From: Simon Davis
Sent: 08 November 2018 16:39
To: 'Nick Hebden'
Subject: FW: Planning Consultation on: BR/263/18/PL

NOTIFICATION FROM ARUN DISTRICT COUNCIL
Town & Country Planning Act 1990 (as amended)
Town and Country Planning (Development Management Procedure) (England) Order 2015
Planning Permission
APPLICATION **BR/263/18/PL**

Registered: 1st November
2018
Site Address: St Josephs Albert Road Bognor Regis PO21 1NJ
Grid Reference: 493977 990845

Description of Works: Application for variation of conditions following grant of planning permission BR/348/16/PL relating to Cond 2 - Block plan & smoking shelter, Cond 9 - smoking shelter materials & Cond 11 - use of smoking shelter & conservatory.

CLIENT Butlins Skyline Ltd.
PROJECT St Josephs
DRAWING TITLE Smoking Shelter

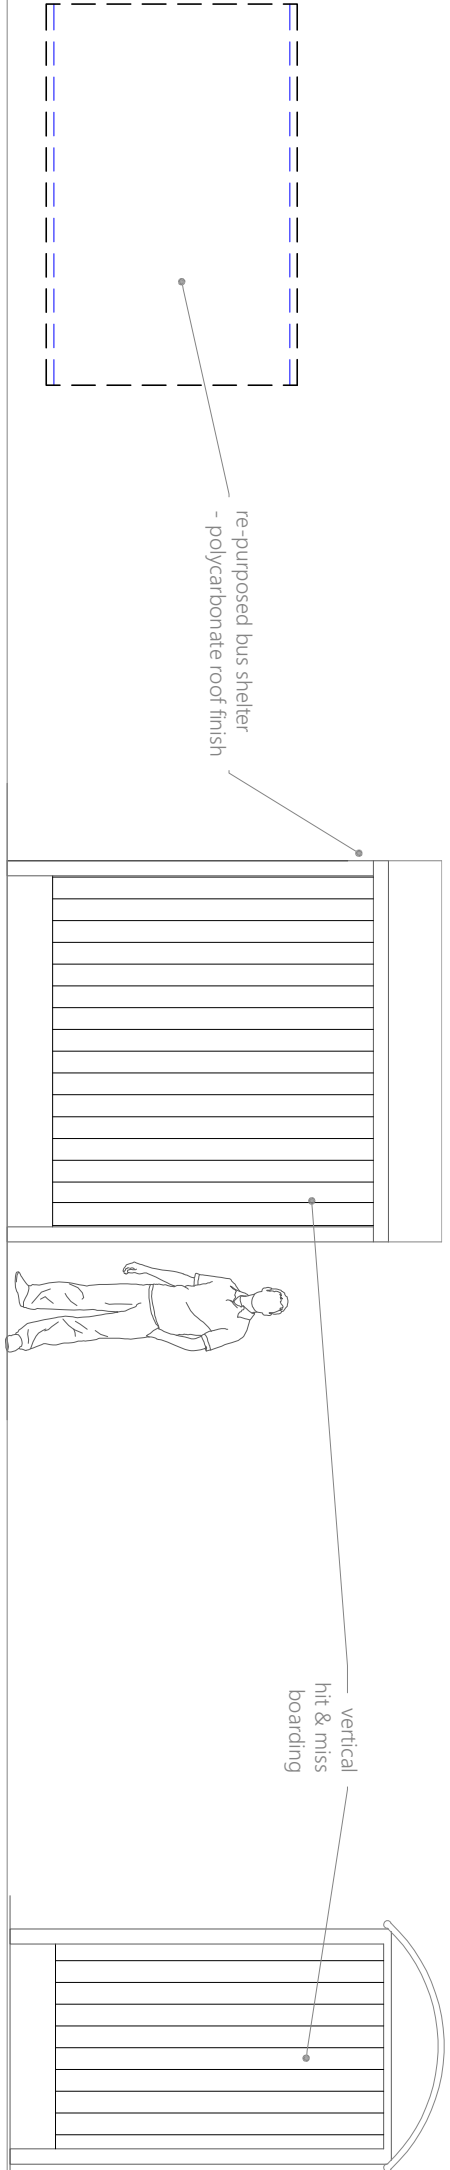
I can confirm that Environmental Health have no objection to the intended increase in the size and location of the smoking shelter provided the time restrictions are still applied (no use between 22.00 and 07.00). I would also request that the western side of the shelter which faces towards the rear of Las Arenas is made of solid construction to reduce noise break out. When constructing the shelter the applicants should note that at least 50% of the shelter construction should be open, so with a roof there should only be one other wall. The other conditions in relation to the shelter should remain.
